REPORT UPDATE

Application No: FG/206/17/PL

REF NO: FG/206/17/PL

PROPOSAL: Installation of a Six Pump (12 Filling Position) Petrol Filling station, Drive-to-Pay Kiosk & associated works including Jet Wash, Air/ Water Services & Vacuum Equipment

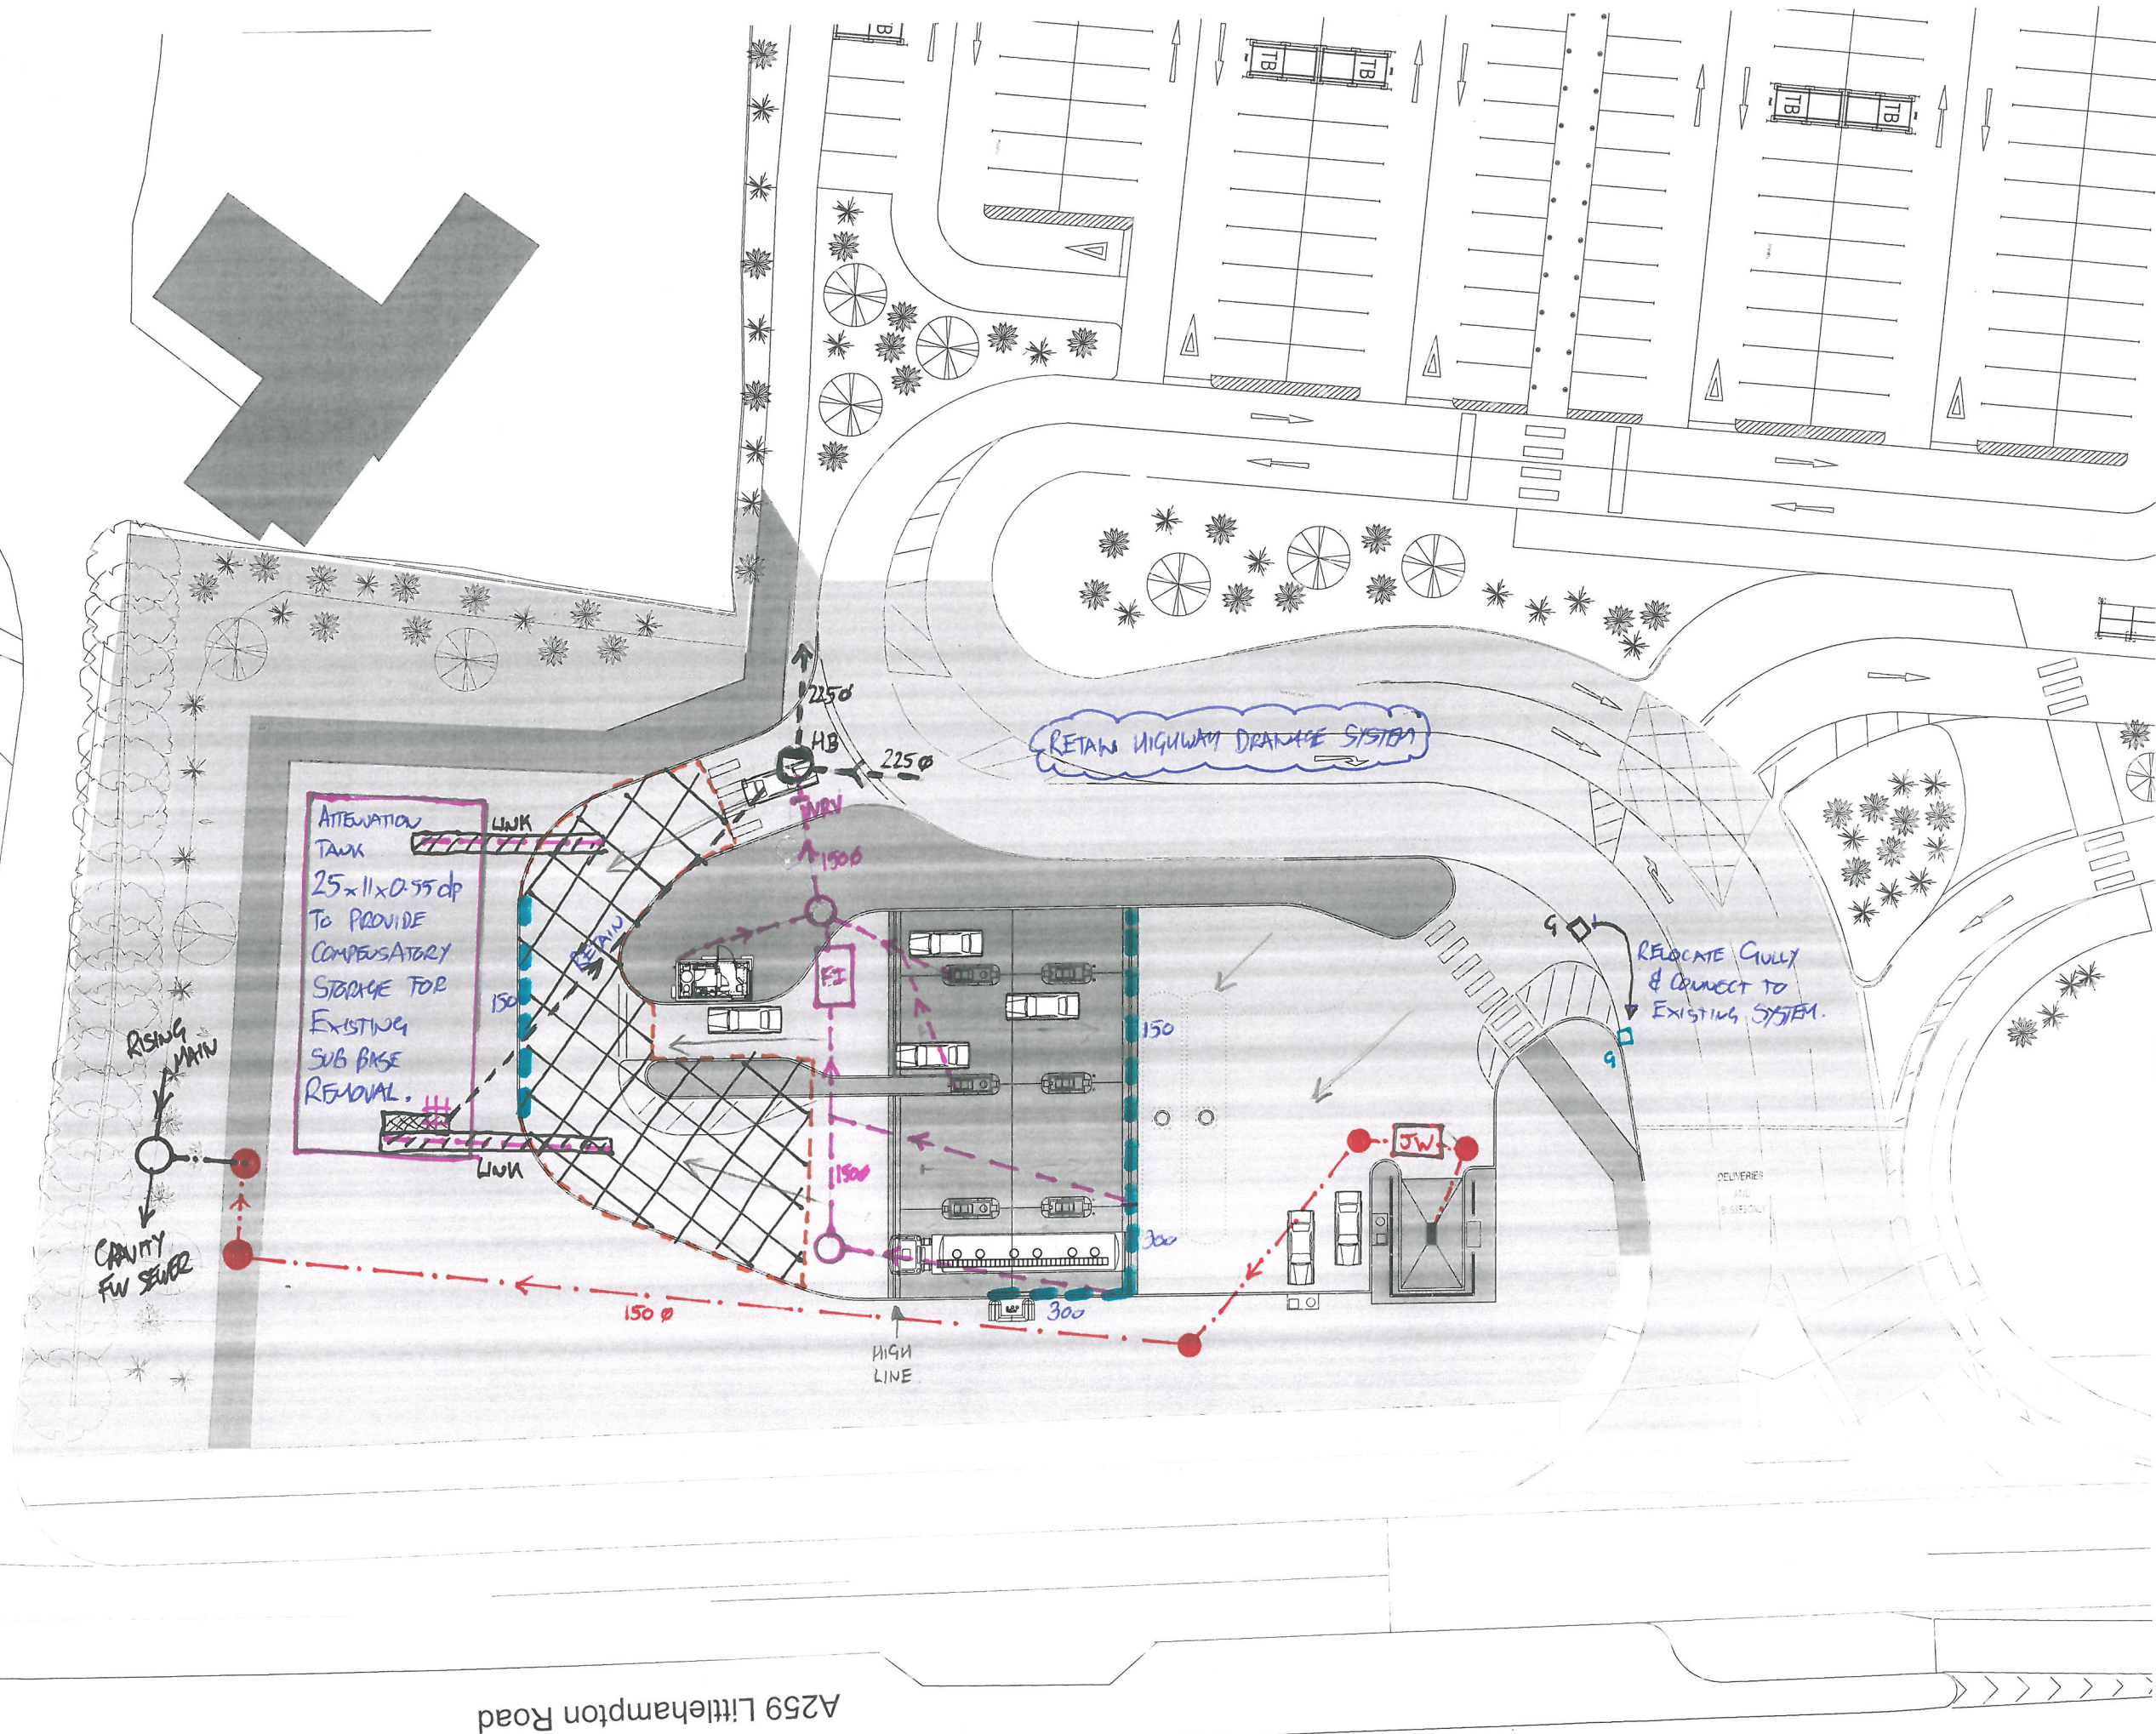
The application proposes to attenuate surface water before discharging using an existing hydrobrake to control the volume discharged from the site. It is stated that infiltration is not suitable because of ground conditions, but no evidence of winter infiltration testing has been provided. This will need to be provided.

Calculations will need to be updated to include for +40% climate change.

It is good to see that the drainage from the hazardous zone is to go to foul sewer and not to surface water disposal. In principle the plans are agreed, if it can be proven that infiltration is not feasible. Further details will be required to discharge the condition.

Winter groundwater monitoring to establish highest annual ground water levels and Percolation testing to BRE 365, or similar approved, will be required to support the design of any Infiltration drainage.
